CITY OF PORTLAND BUILDING PERMIT

Job ID: 2011-09-2161-CH OF USE

has permission to Change the Use from market with 1 dwelling above to ^{artist studio} ~~artist studio~~ retail pottery/café, renovate space provided that the person or persons, firm or corporation accepting this permit shall comply with all of the provisions of the Statues of Maine and of the Ordinances of the City of Portland regulating the construction, maintenance and use of the buildings and structures, and of the application on file in the department.

Jeanie Bourke - FW: 122 Washington ave permit review

Portland Pottery  
Details

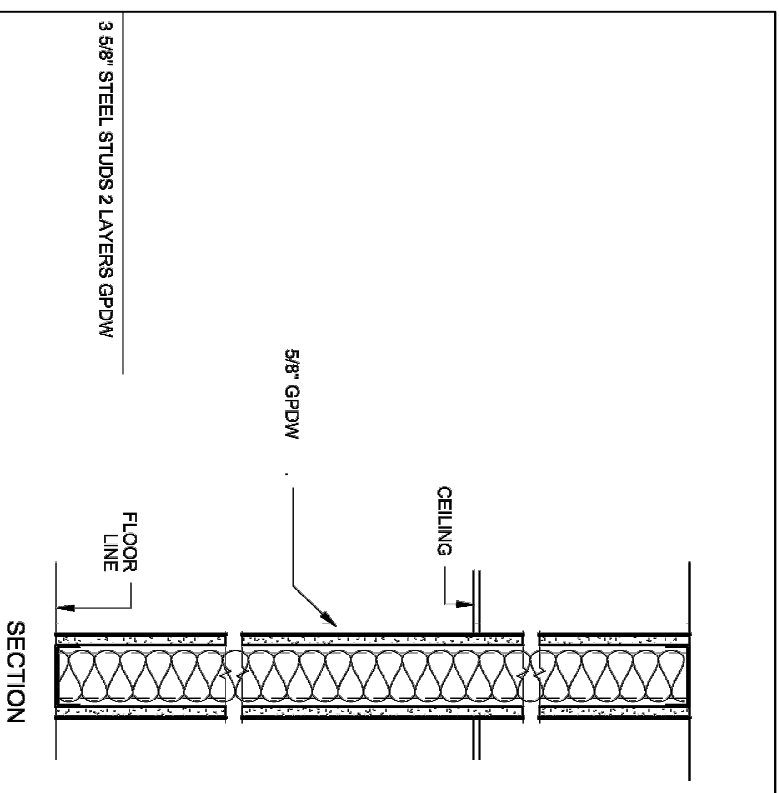
- Pottery studio considered F-2 use, 2 hour separation required from mercantile per Table 508.4 with opening protections, fire door

We will have 2 layers of Type X drywall on each side of the metal stud wall partition with a fire rated door.

# PORTLAND POTTERY CAFE AREA DETAIL

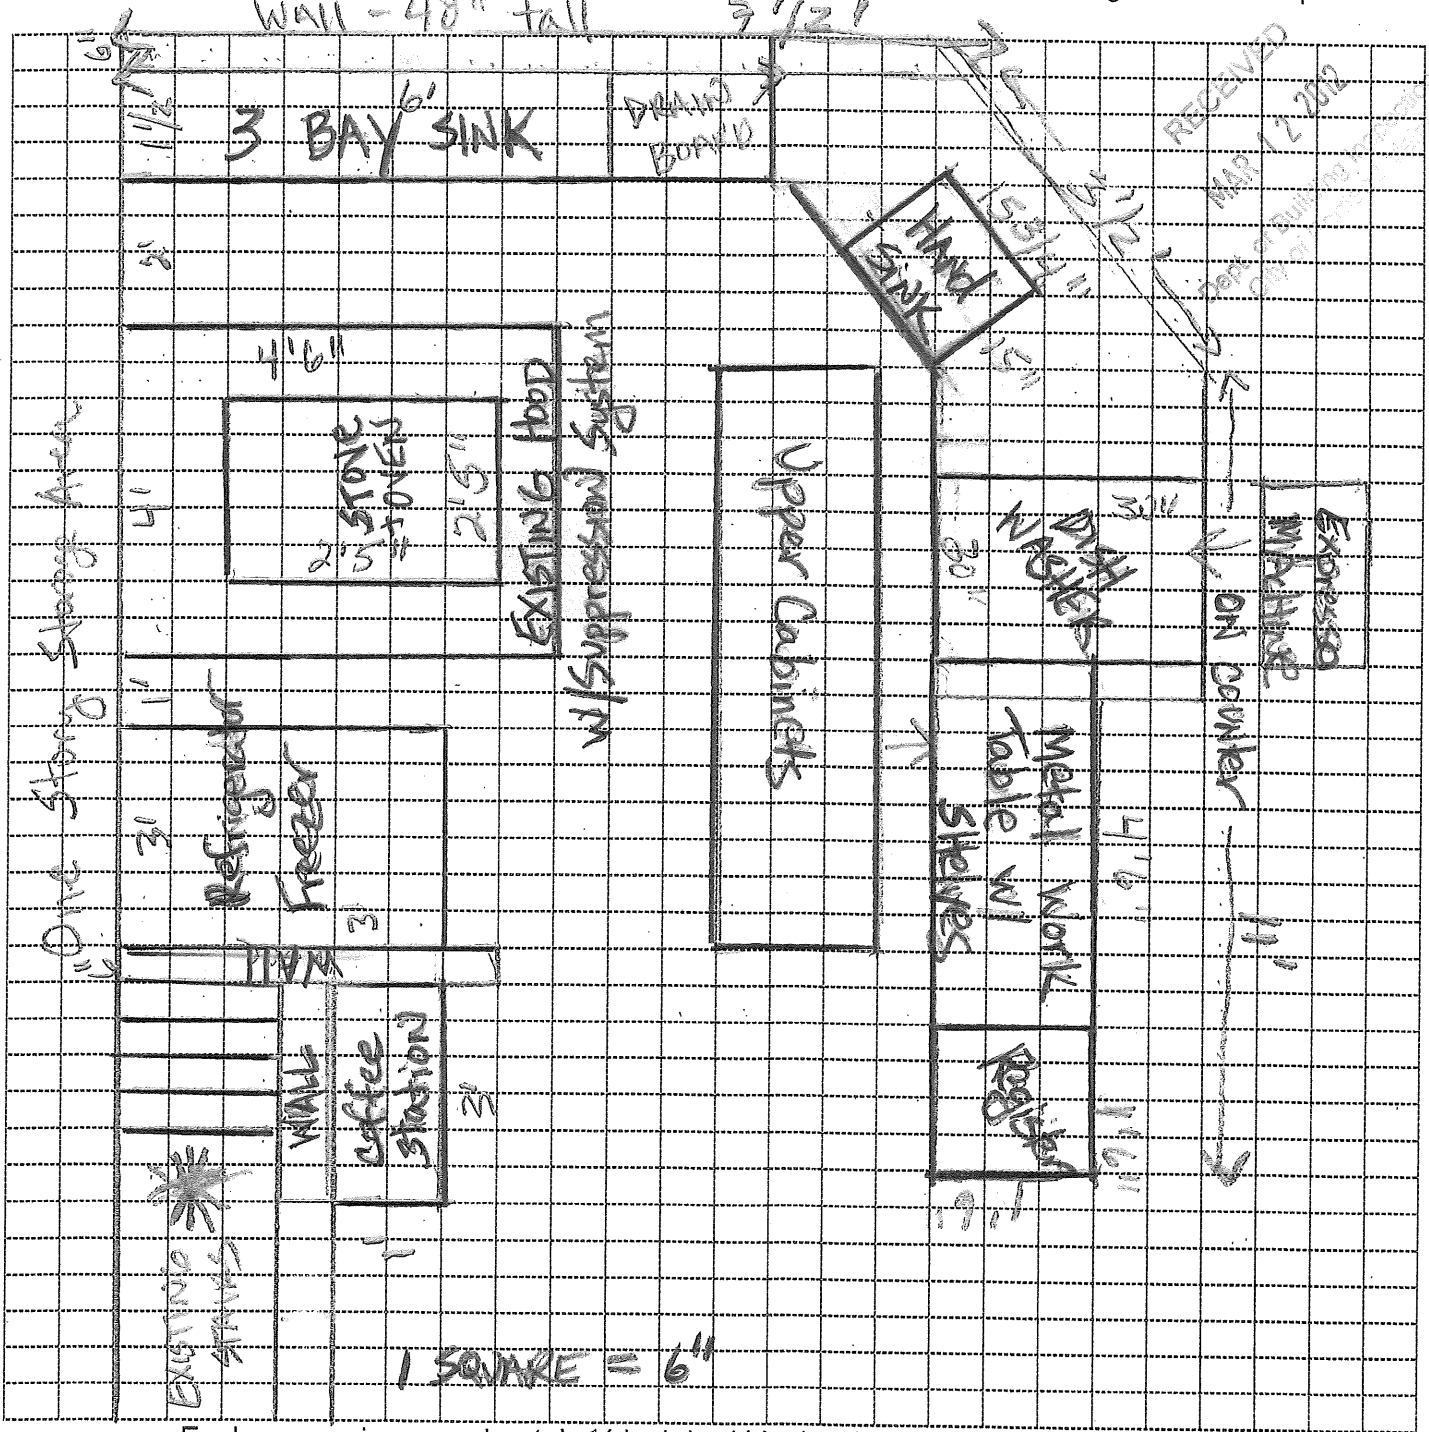
- Floor plan/fit up for café and studio including plumbing fixtures

Attached
